From: Zac Denton
Sent: 10 April 2019 09:34
To: 'Russell McCourty'
Subject: RE: R/36/19/HH - 12 Central Avenue, Rustington

From: Russell McCourty [REDACTED]
Sent: 18 March 2019 16:04
To: Zac Denton
Subject: R/36/19/HH - 12 Central Avenue, Rustington

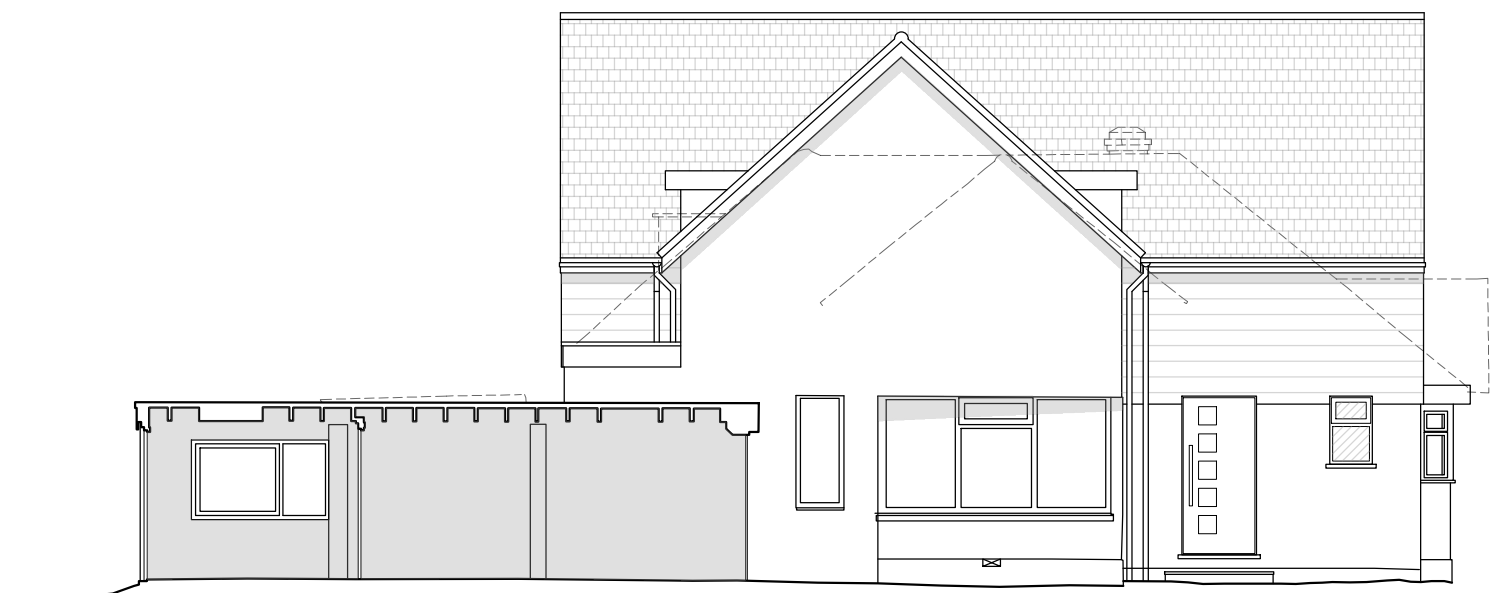
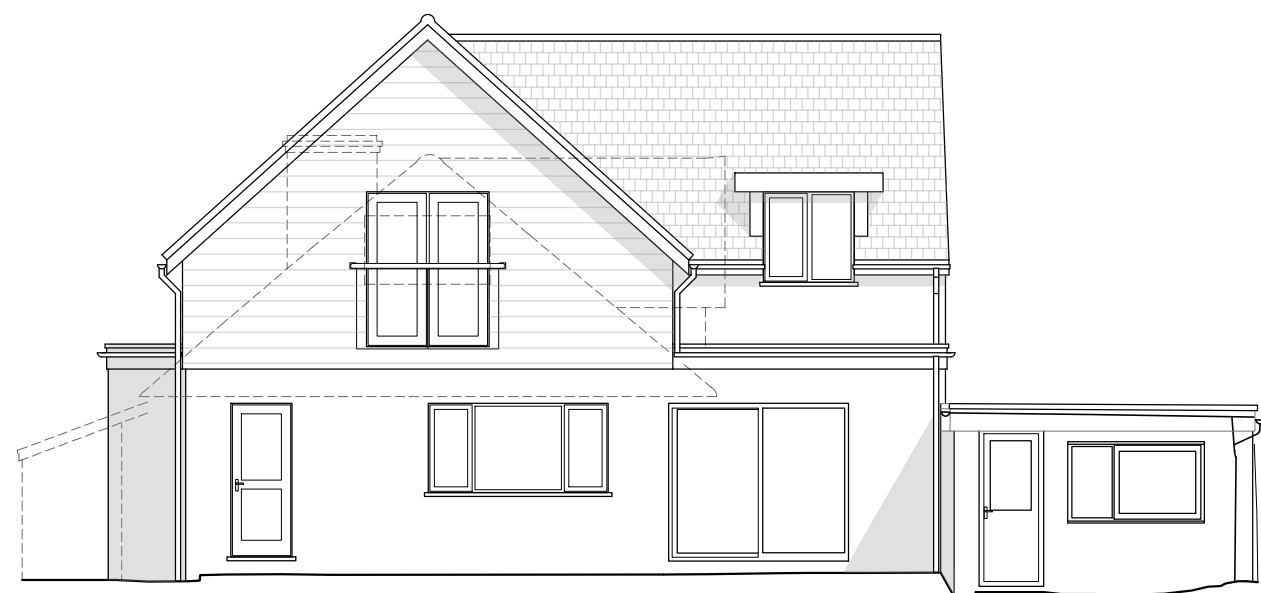
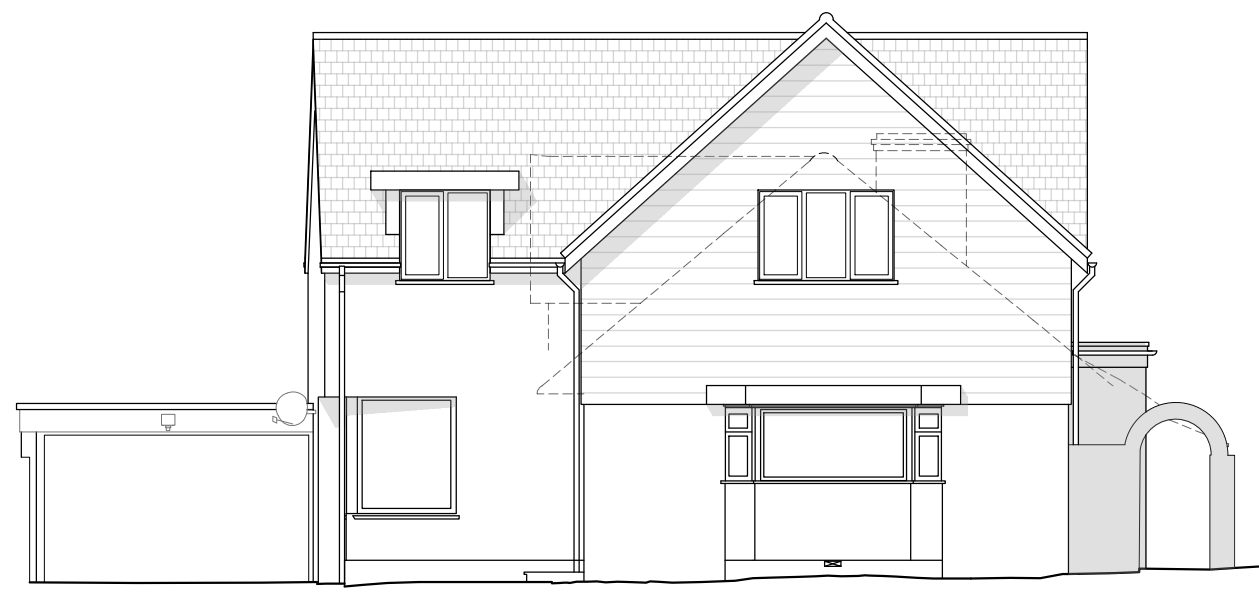
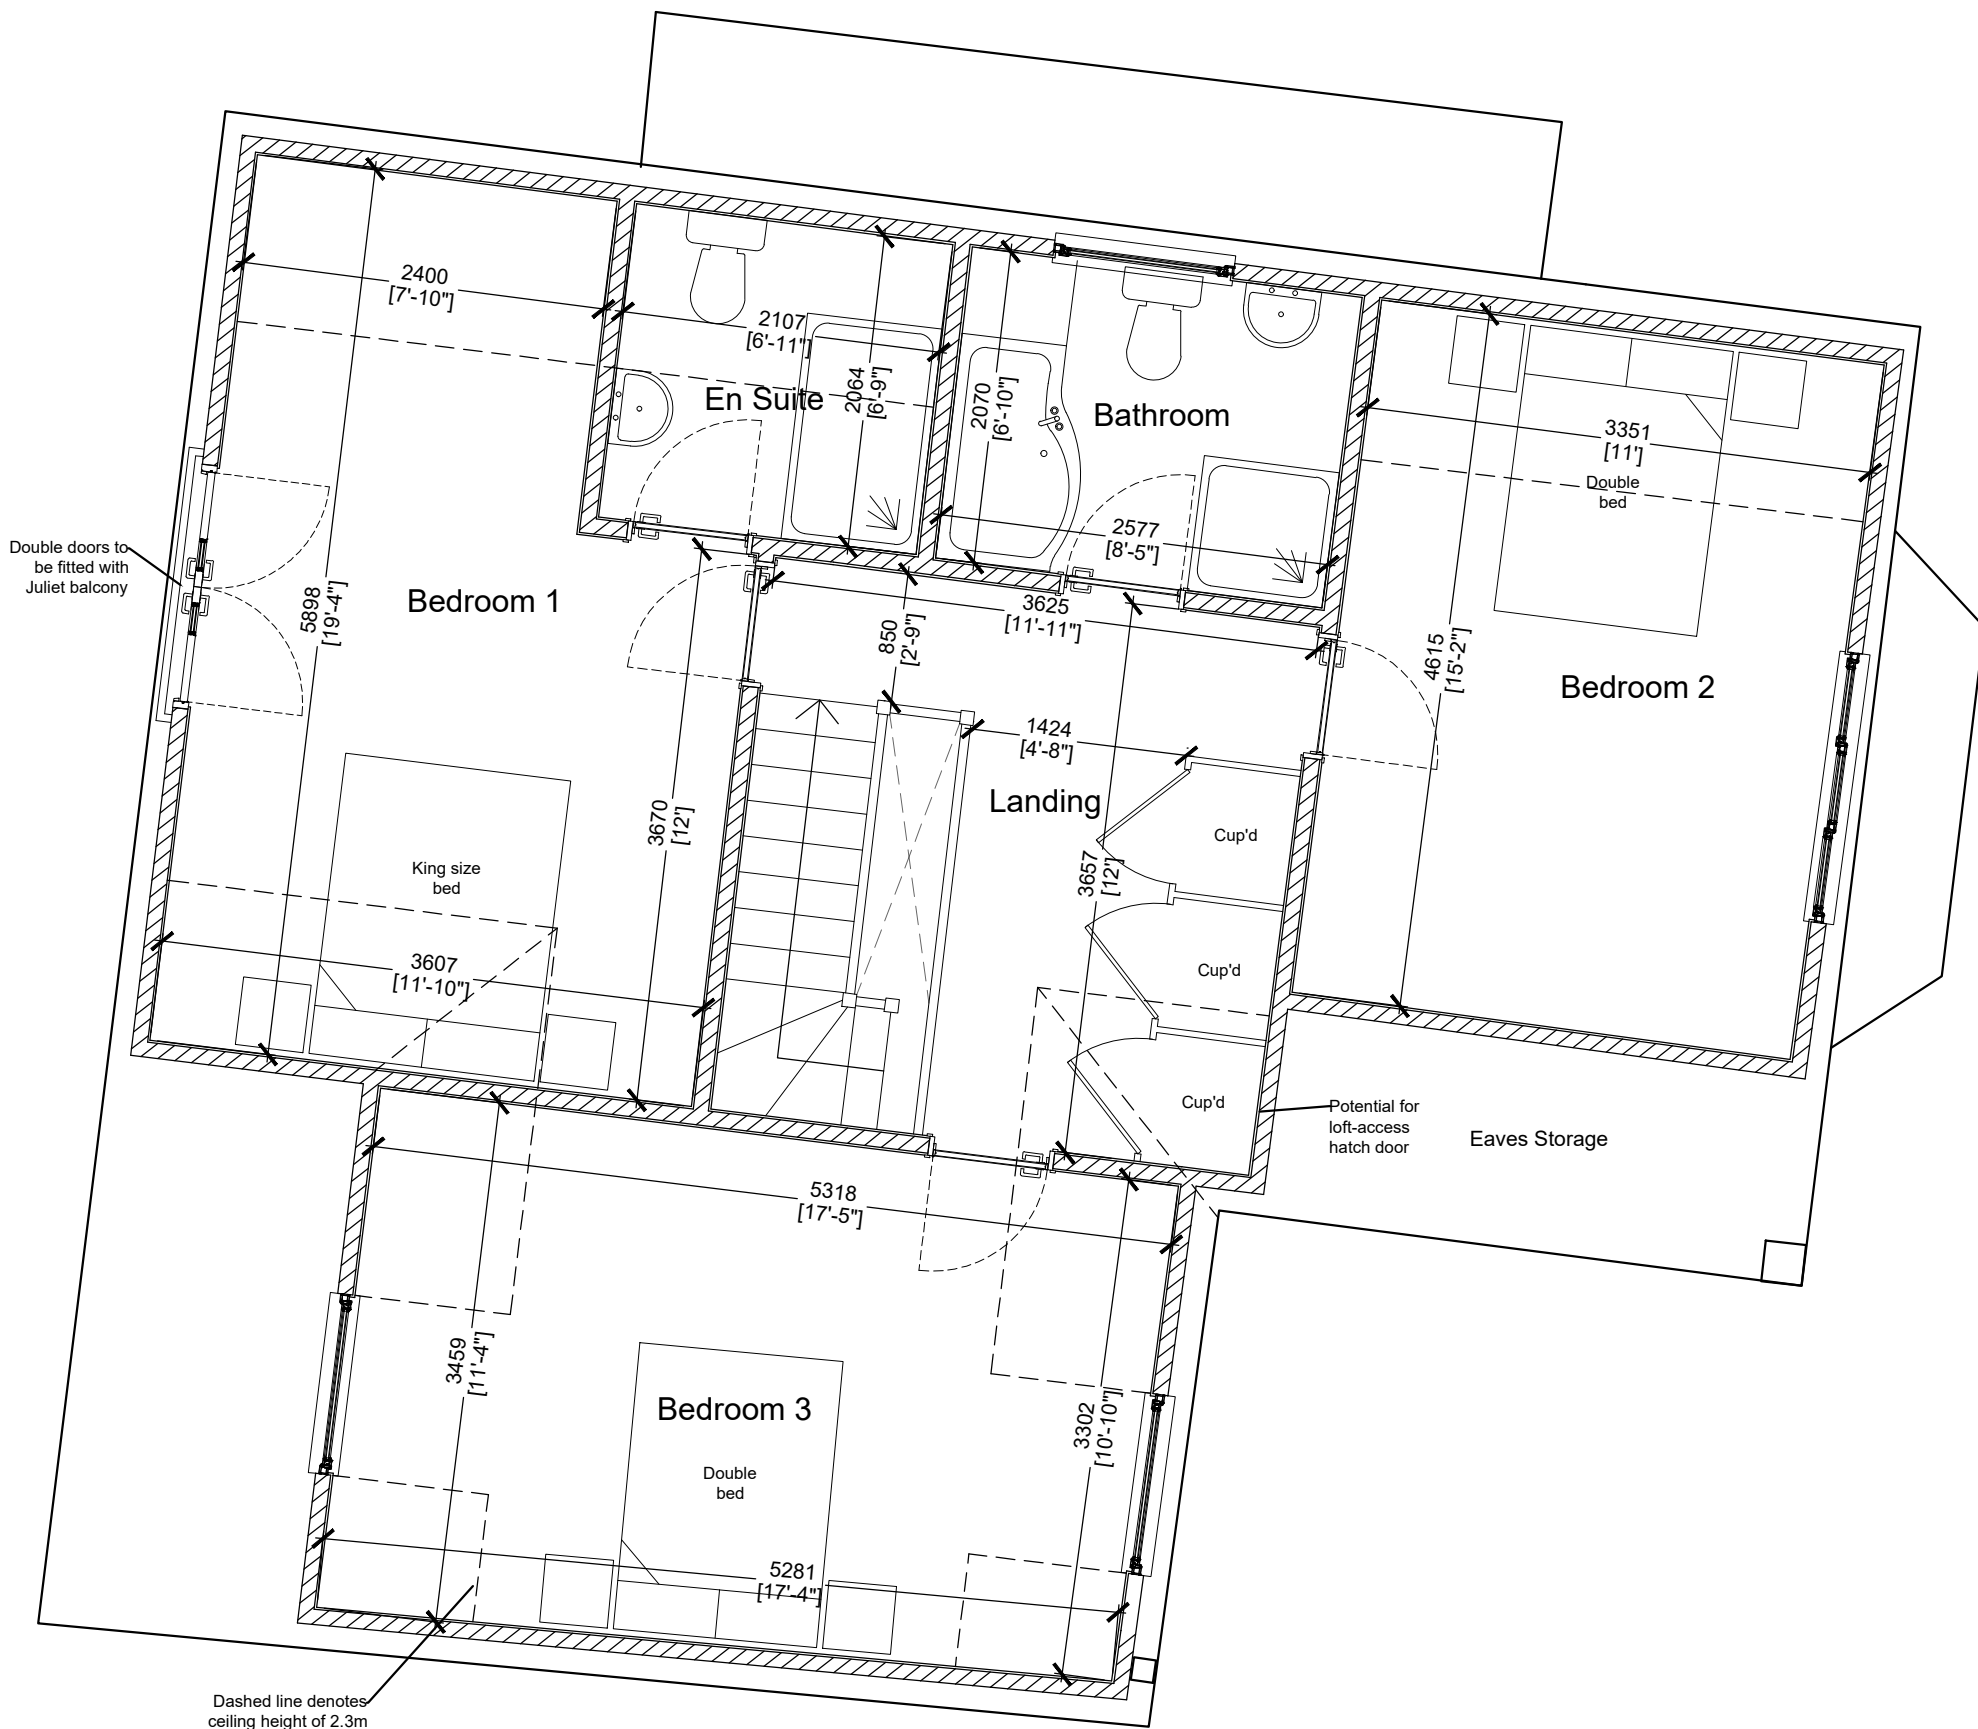
I am aware that there is a comment from the immediate neighbour to 12 Central Avenue, Rustington which requests obscure glazing to the proposed, first floor North window within this Householder Application. I would like to respond to say that this is a perfectly reasonable request and it is already shown shaded as obscure glazing on the proposed elevations. As this window is serving a bathroom, we would install obscure glazing anyway. However, should you feel it necessary, we would agree to a restrictive condition to any approval for this window to be obscure glazed in perpetuity.

In this case I think it is likely that we will impose a restrictive condition, as this then secures the window as obscure glazed in perpetuity.
